Application Ref:	3/2026/0085			 Ribble Valley Borough Council www.ribblevalley.gov.uk
Date Inspected:	N/A	Site Notice:	N/A	
Officer:	MC			
DELEGATED ITEM FILE REPORT:				REFUSAL

Development Description:	Certificate of Lawfulness for existing outbuilding store (to the rear of the garage), extension to an existing pond, new access to highway and areas of hardstanding.
Site Address/Location:	Megitta House, Kenyon Lane, Langho, BB6 8AN

PROPOSED
OUTBUILDING 1
STORE

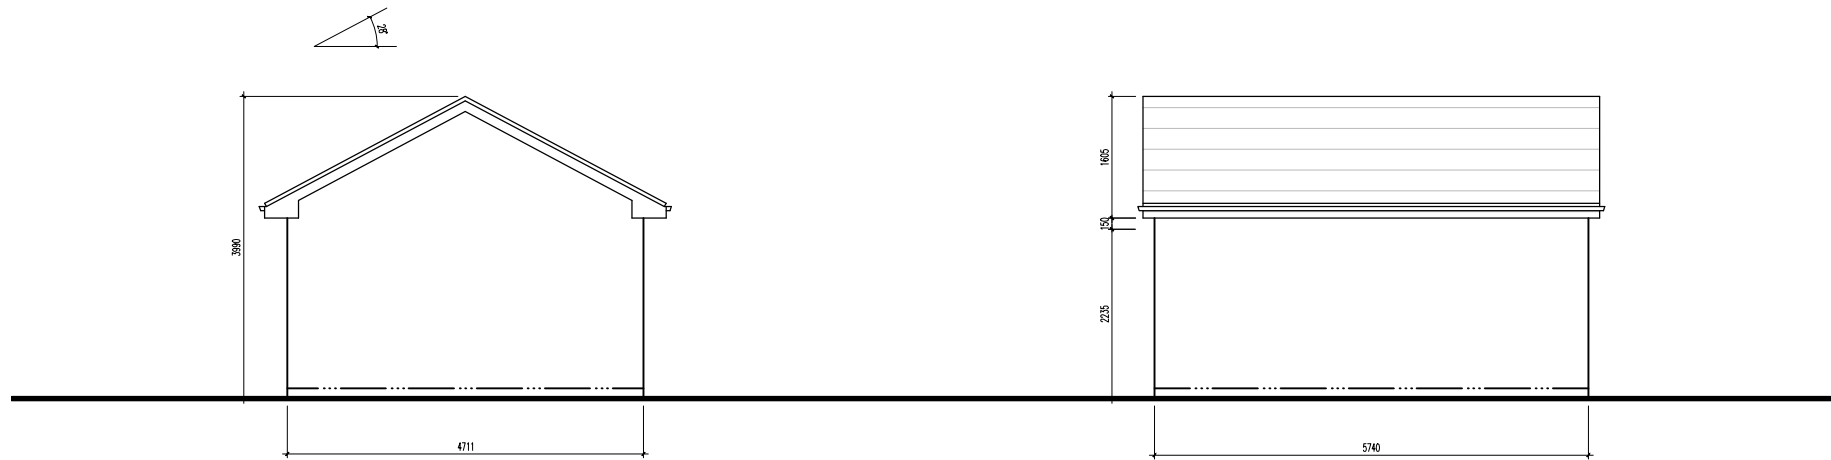
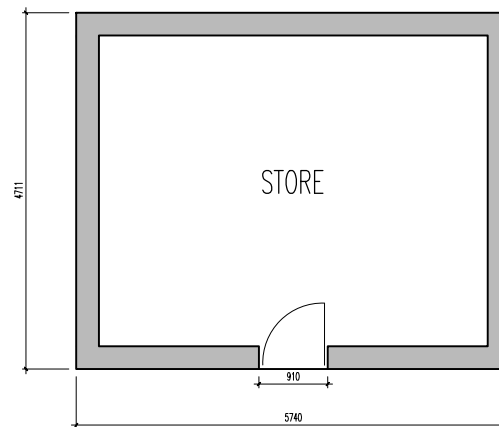
The Council considers that the outbuilding is sited on land which is outside of the curtilage of the dwellinghouse, which as previously set out is considered to be the area of land in the general location included within the pink shaded area within figure 15 of the applicants planning statement, and therefore does not fall to be assessed under Schedule 2, Part 1, Class E of The Town and Country Planning (General Permitted Development) (England) Order 2015 (as amended). As such, an application for planning permission is required.

02:	The outbuilding store as shown on drawing ref: D0275/306 Rev G is sited outside the curtilage of the existing dwellinghouse and does not fall to be assessed under Schedule 2, Part 1, Class E of the Town and Country Planning (General Permitted Development) (England) Order 2015 (as amended). An application for planning permission is therefore required.
